15 March 2022

Department of Planning and Environment
Team Leader, Social Infrastructure
Social & Infrastructure Assessments

**Subject: St John of God Richmond Hospital Redevelopment (SSD-10394)
Request for Information (RFI-37865572)**

Figure 16 | Height exceedances and RL levels (compliant heights are shown in light pink with exceedances in white/grey). Minor revisions to this layout were made at SRtS stage, however the heights and RLs remain unchanged. (Source: Applicant's EIS)

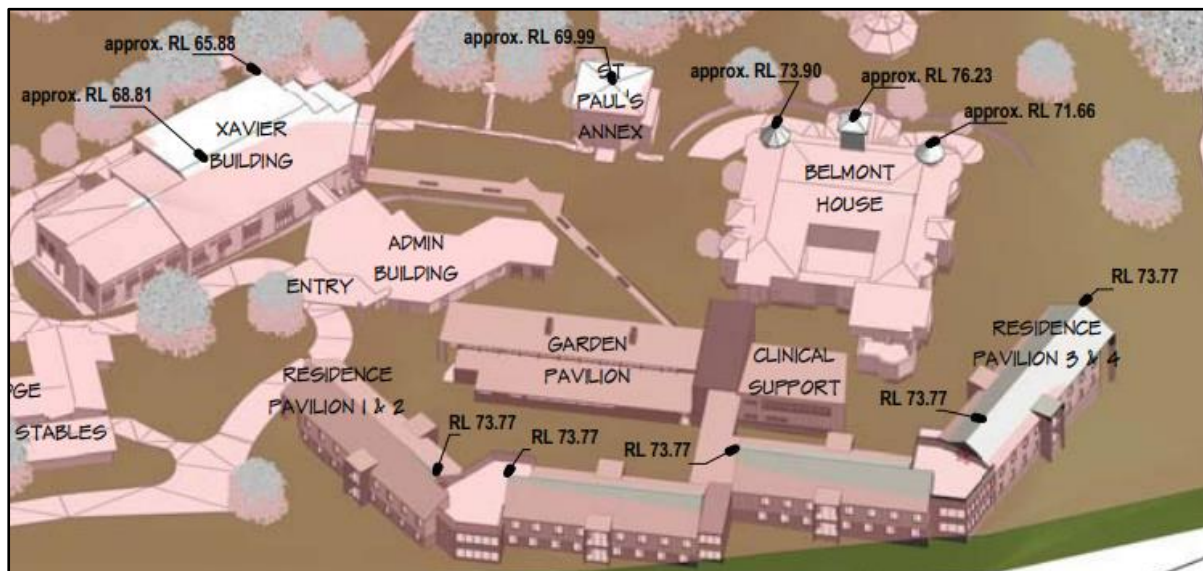
3.	Provide the height exceedances of pavilions 2 and 3 in metres – no updated Clause 4.6 necessary.	The maximum height of the Residence Pavilion roof ridge has not changed and therefore the exceedance breach to Pavilion 2 & 3 remain unchanged. Pavilion 4 was rotated and now sits on existing land that is not as steep. The rotation of Pavilion 4 results in the exceedance breach of 2.1m (rounded) This is identical to the exceedance breach occurring at Pavilion 3 being 2.1m.
----	--	---

Figure 18 | Tree removal plan (Source: Applicant's SRtS)

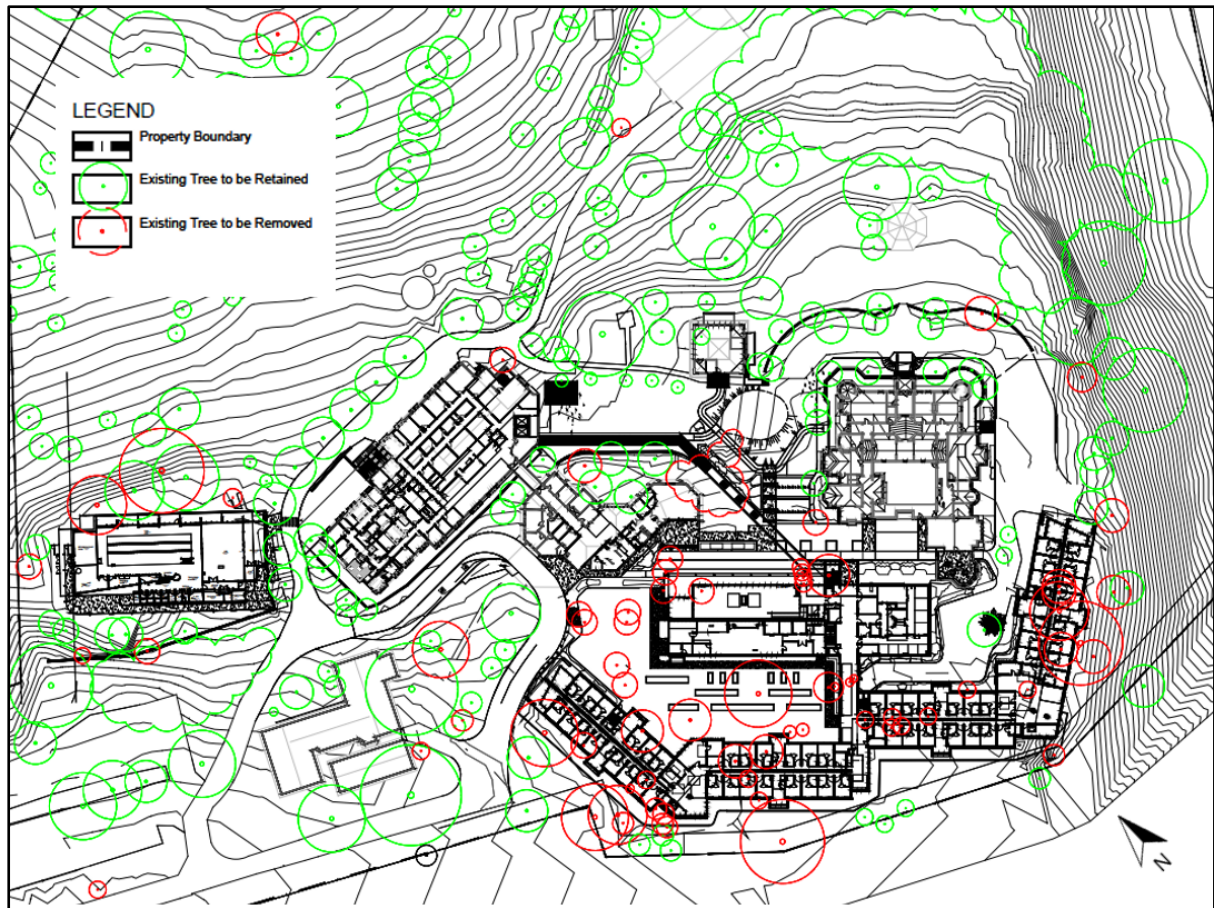
2.	Provide a cover letter prepared by a qualified specialist, correcting the original BDAR by clarifying: <ul style="list-style-type: none"> the tree species within the Shale sandstone transition forest TEC being sought for removal – currently a Forest Red Gum is listed within the BDAR for removal but is not listed on the most recent tree removal plans provided. the BDAR does not note the removal of a narrow-leaved ironbark which is identified on the tree removal plans, please clarify 	Through miscommunication there remained some ambiguity with regards to the BDAR & removal of tree information provided to DPIE. Further consultation with the biodiversity consultant and arborist has provided clarity into a particular tree species to remain and be removed within the projects site. Appendix A is a letter from Cumberland Ecology confirming tree species for removal and retention. This is also consolidated with the arborist tree removal data. Appendix B is the coordinated tree removal plan.
